**From:** Cherne, Curtis  
**Sent:** Friday, April 10, 2015 8:10 AM  
**To:** 'Kevin Cobos'  
**Subject:** RE: SWPPP at Greater Albuquerque housing on 4th street

**From:** Cherne, Curtis [<mailto:CCherne@cabq.gov>]  
**Sent:** Thursday, April 9, 2015 10:22 AM  
**To:** Kevin Cobos  
**Subject:** SWPPP at Greater Albuquerque housing on 4th street

MY name is Curtis Cherne. I am the SWPPP compliance engineer for the Planning Department in Albuquerque.

EROSION CONTROL PLAN

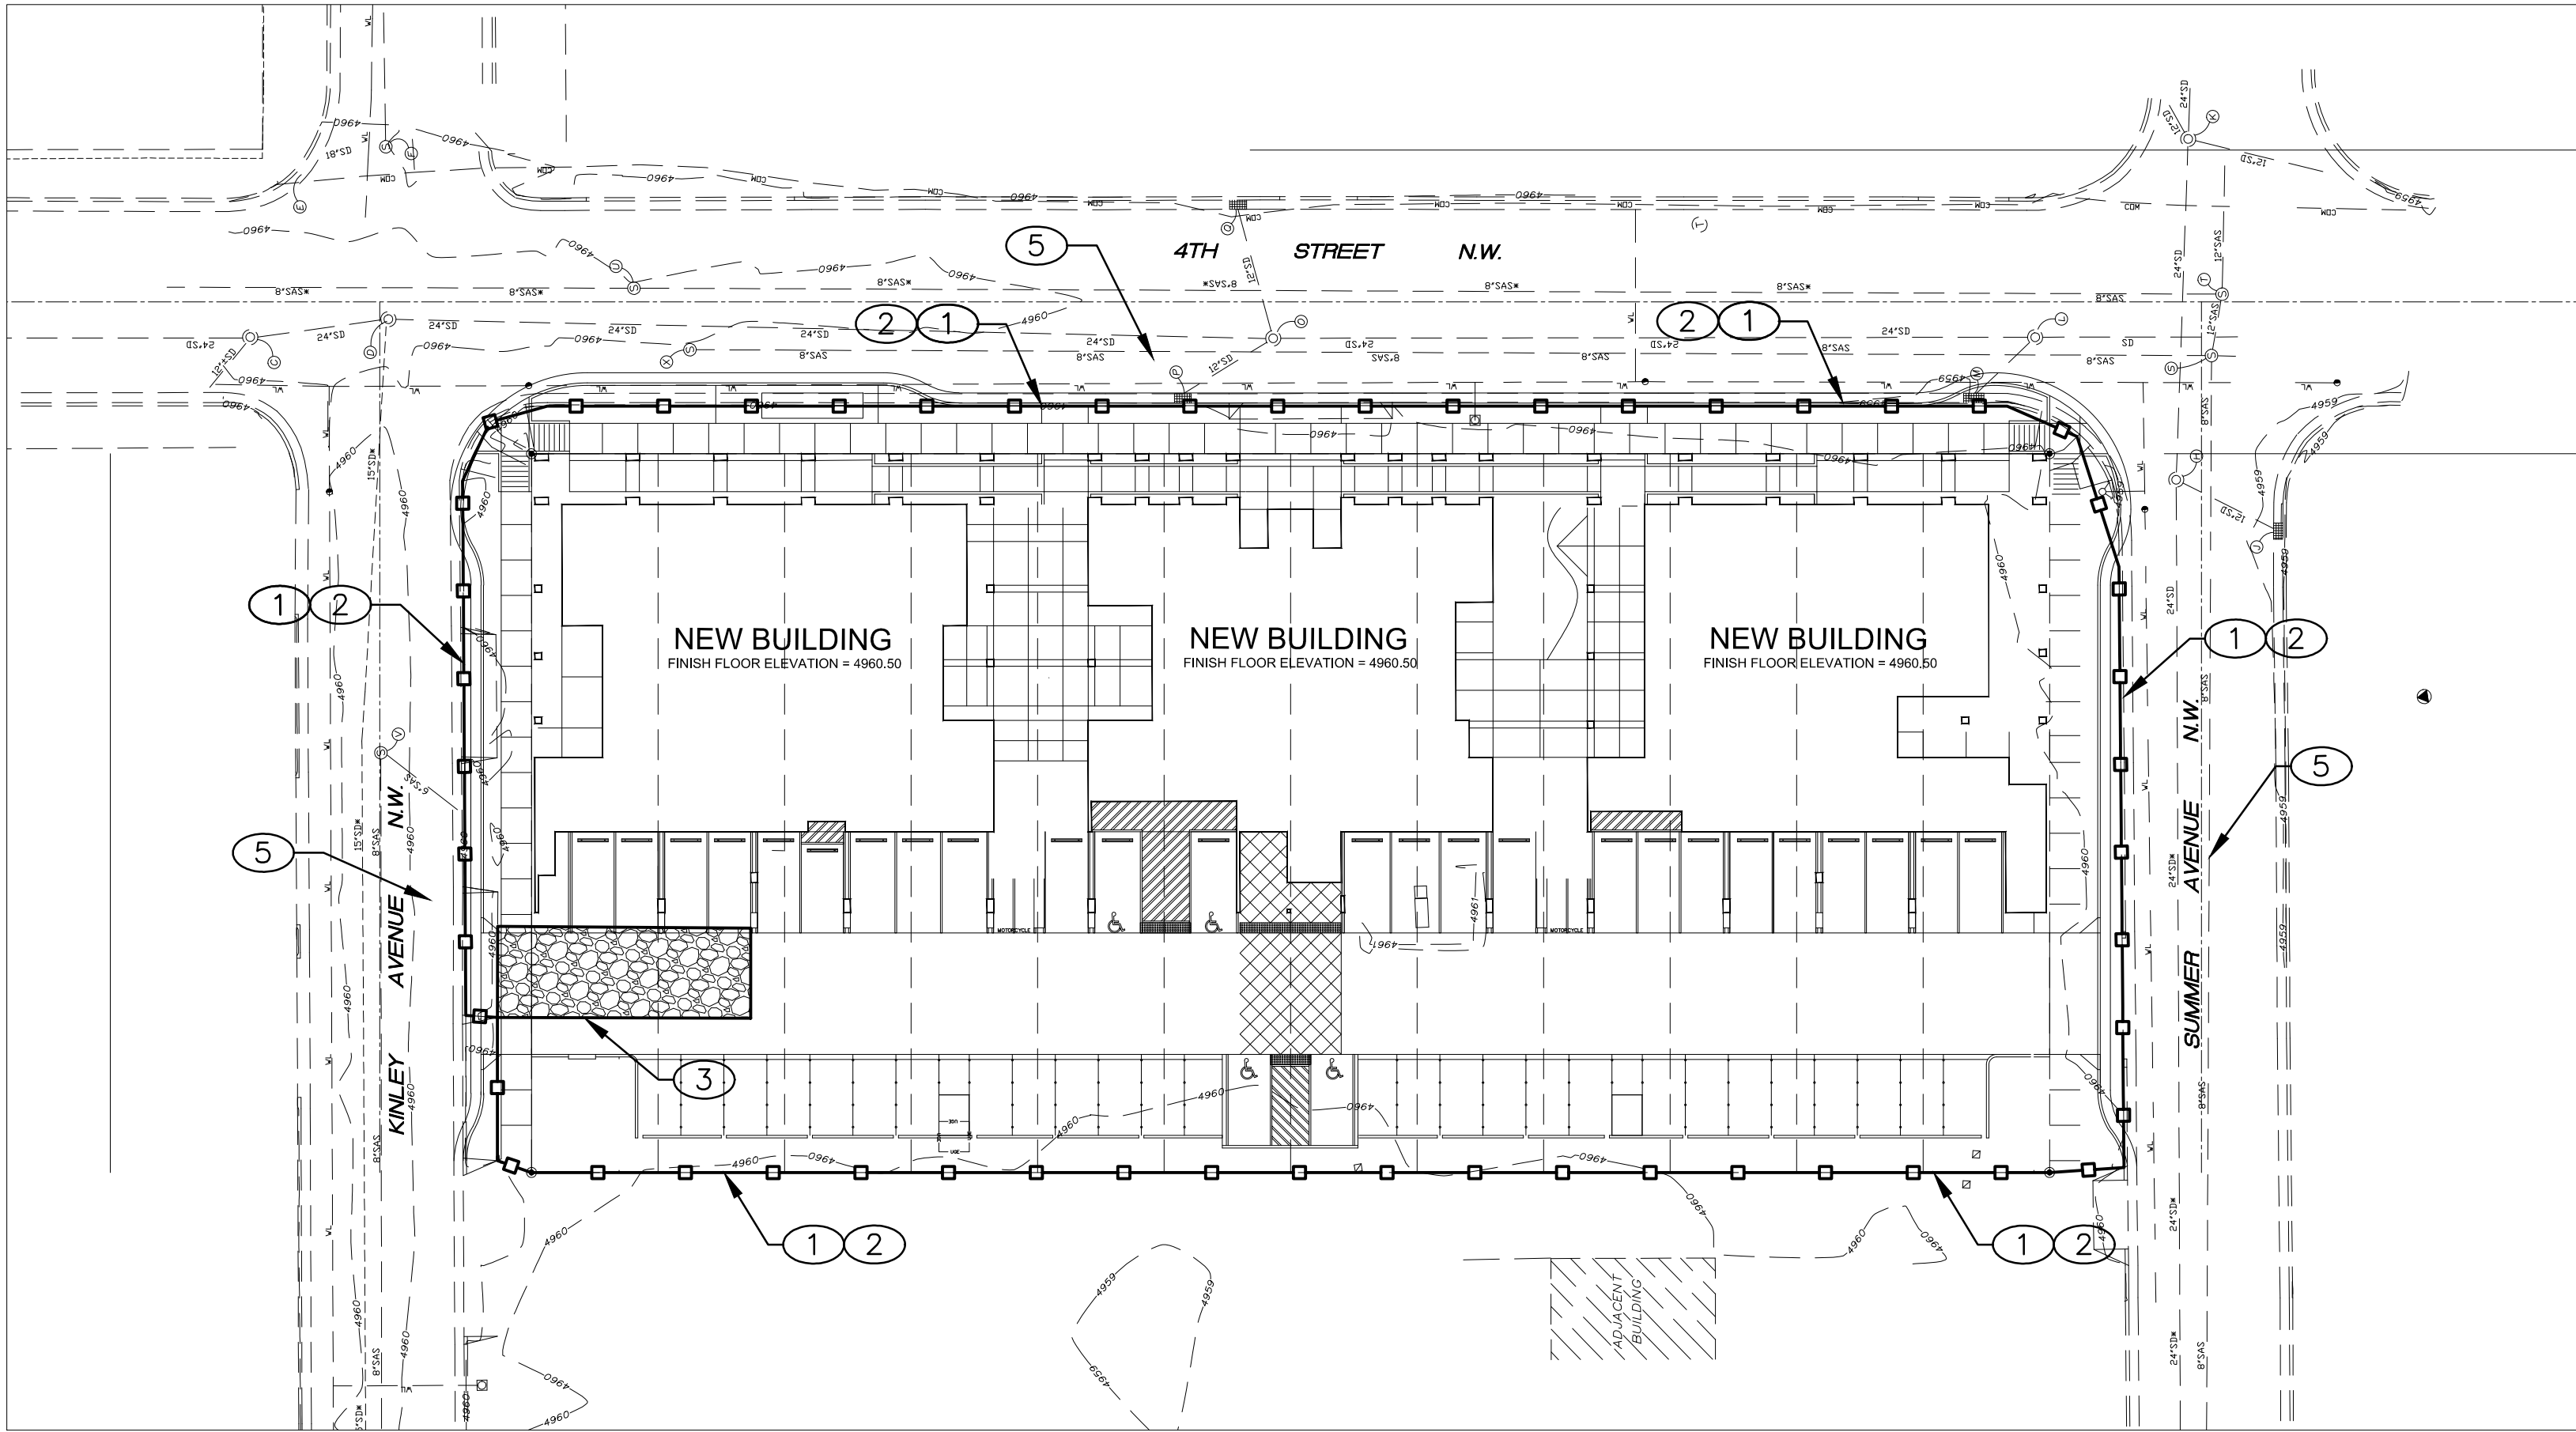
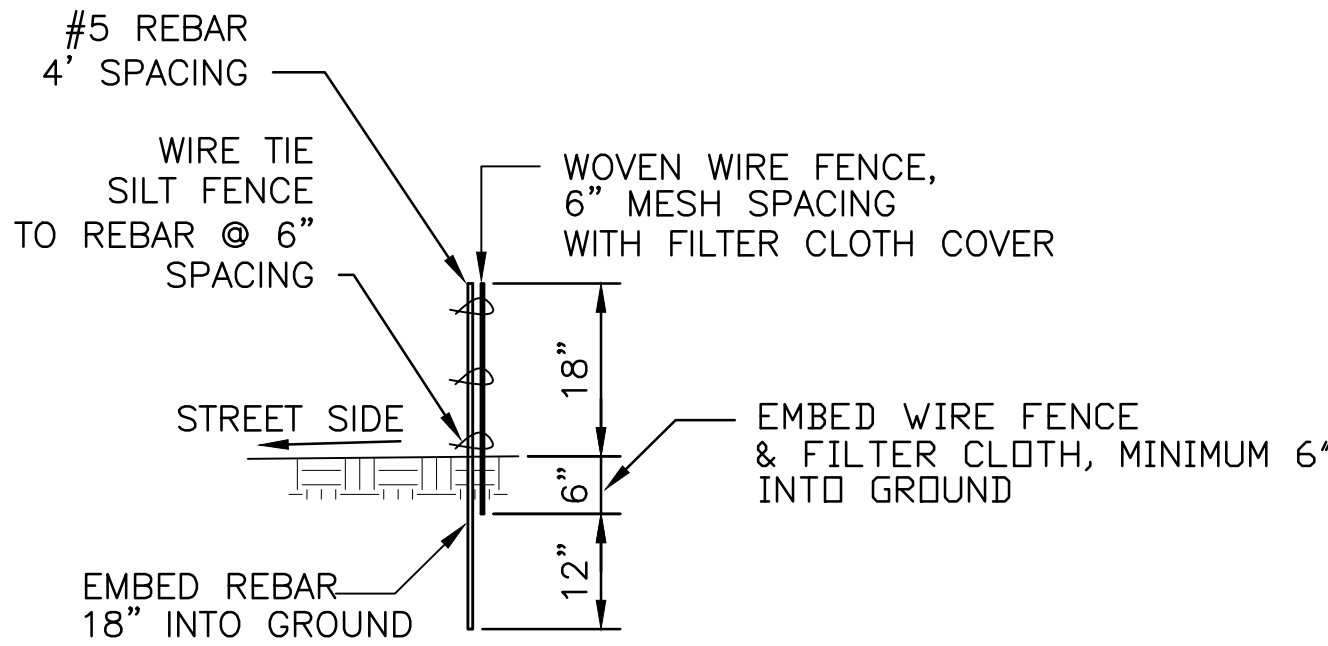
1. 25 feet of silt fence needs repair on Summer Ave.
2. The construction entrance was moved away from the curb cut, so dirt is being used as a ramp.
3. I couldn't find the required posting board per the Construction General Permit.

1. silt fence will be repaired
2. due to over excavation my entrance had to go in this place for safety concerns. I actually have cold patch for the ramp if this is an issue I will fix immediately.
3. the sign, is there a specific SWPP sign that needs to be hung? Or the fugitive dust sign only?
